Engineers Comments Regarding Surface Water Drainage

Application Reference:	FP/70/26/HH	Reviewer Reference:	ADC/KW
Planning Officer:	Rhiannon Lloyd	Date of Review:	29/07/2026
Site Name:	5 Limmer Lane, Felpham, PO22 7EL		
Application Description:	Single storey rear extension. First-floor side extension with hip-to-gable roof conversion over. Garage remodelling with installation of PV panels on proposed new pitched roof.		
Assessment Number:	1 of 1

Drawing
Site Plan

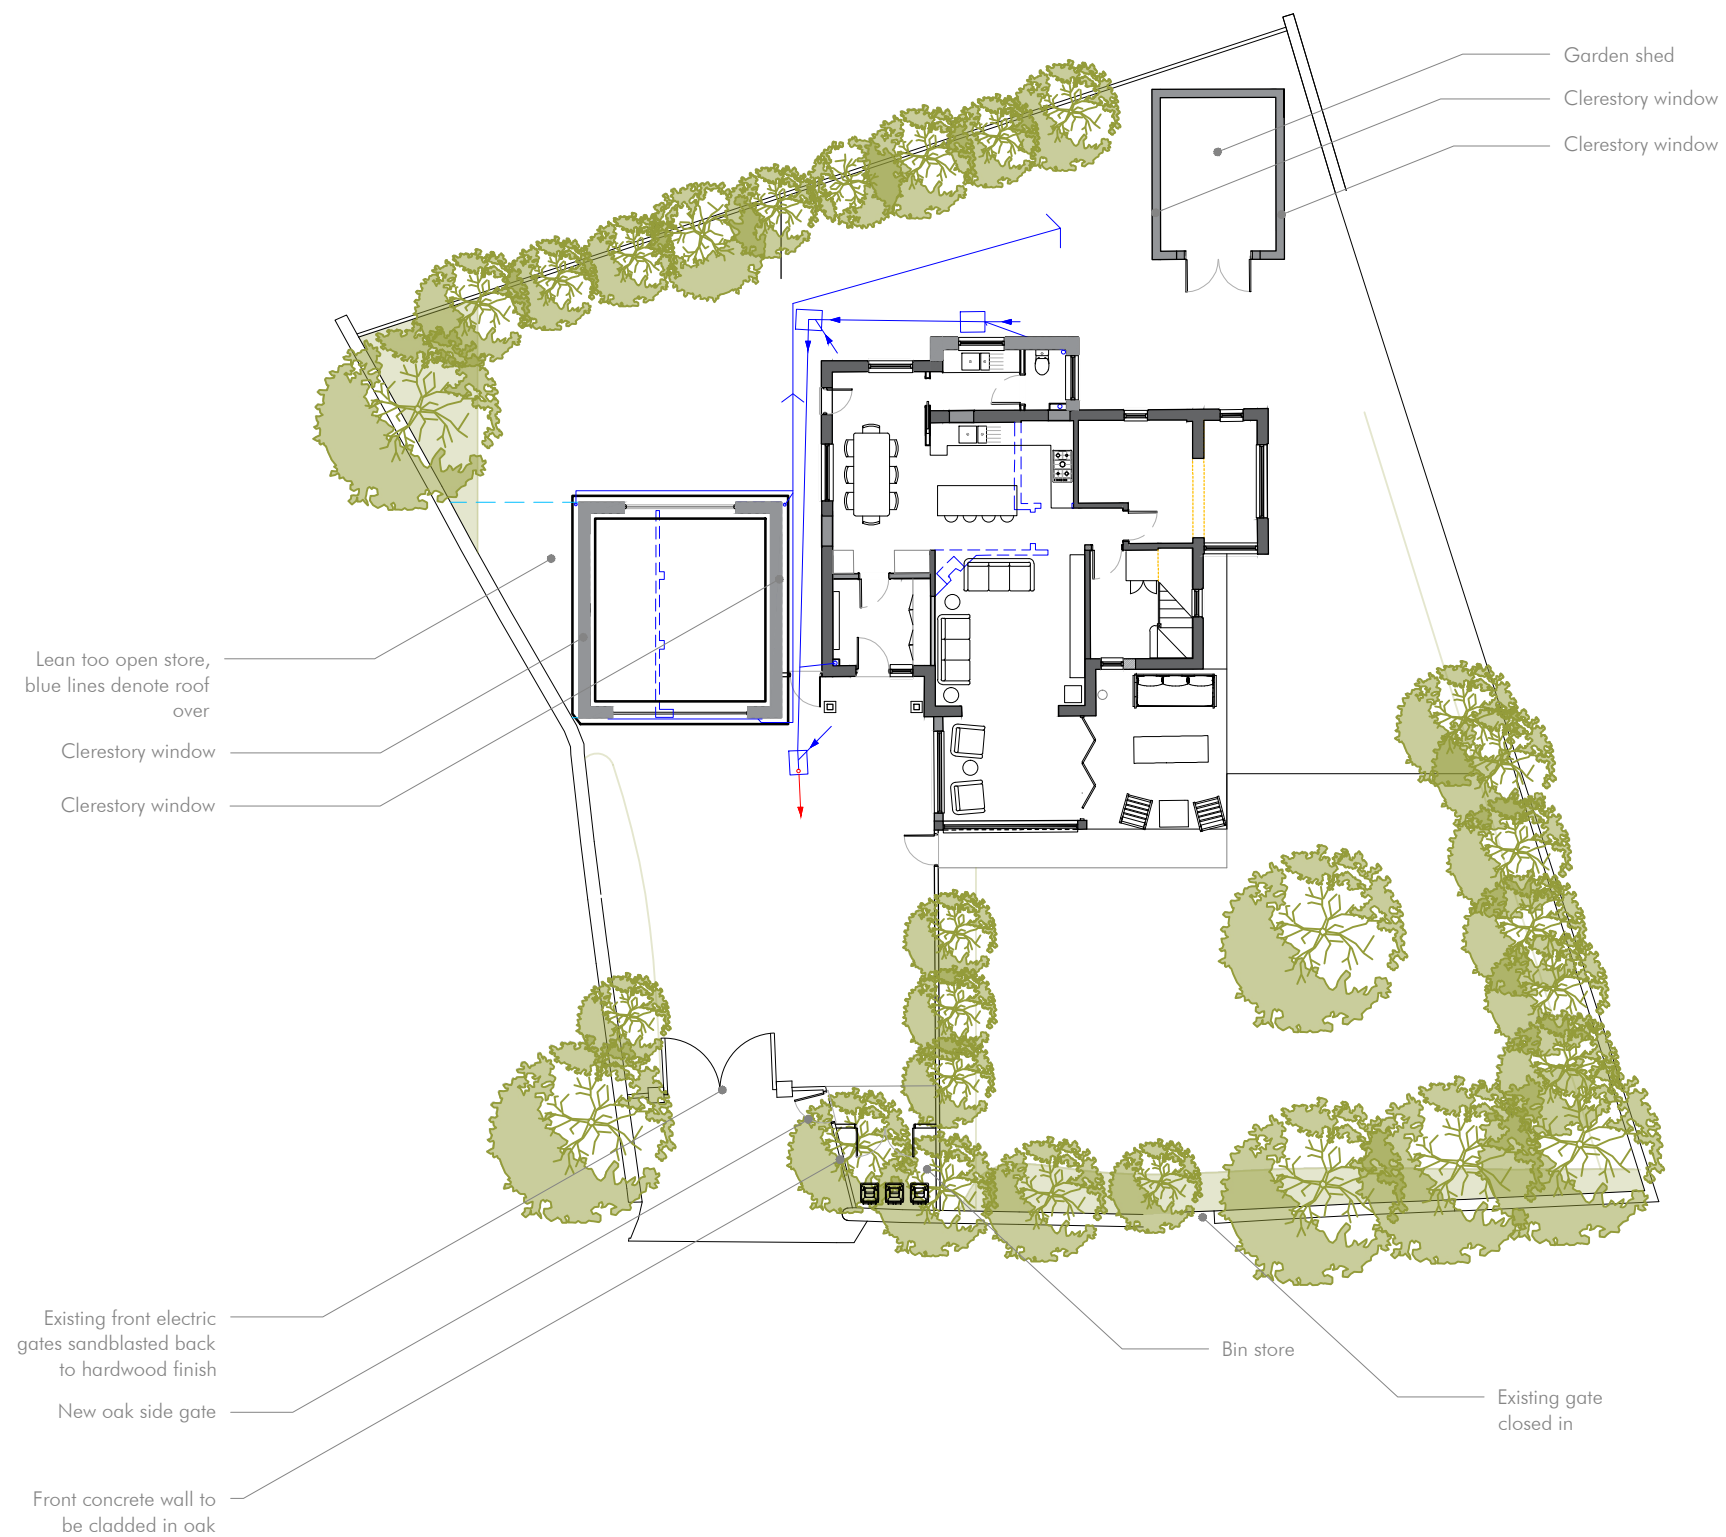
It is proposed to manage surface water on site via a new soakaway and permeable paving. We support this approach in principle, as infiltration is the highest priority in the drainage hierarchy and aligns with Standard 1 of the Non-Statutory Technical Standards for SuDS (NSfS). However, insufficient evidence

has been provided to demonstrate that infiltration is a viable solution. It is the responsibility of the applicant or their drainage designer to provide this evidence. Without it, we are unable to assess whether the proposed development would increase flood risk. The applicant has also not demonstrated how they may drain the site if infiltration was later found not to be viable. For this reason, we object to the proposal. The submission of such evidence may also affect the scale and layout of the development.

To support an infiltration-based design, winter groundwater monitoring must be undertaken to confirm that a minimum of 1 metre of unsaturated ground can be maintained between the base of the soakaway or infiltration structure and the peak groundwater level. Ground conditions and infiltration potential in Middleton-on-Sea are highly variable. While infiltration may be feasible in some areas, others experience high groundwater levels or poor infiltration rates that render it unviable. This must be robustly demonstrated by the applicant.

At present, no modelling or supporting evidence; such as ground investigations or drainage plans have been submitted for engineering assessment in respect to surface water drainage. In the absence this evidence, we cannot assess if flood risk will be increased by the proposed development. Therefore, this application does not accord with the NPPF as set out above and we object to the proposal.
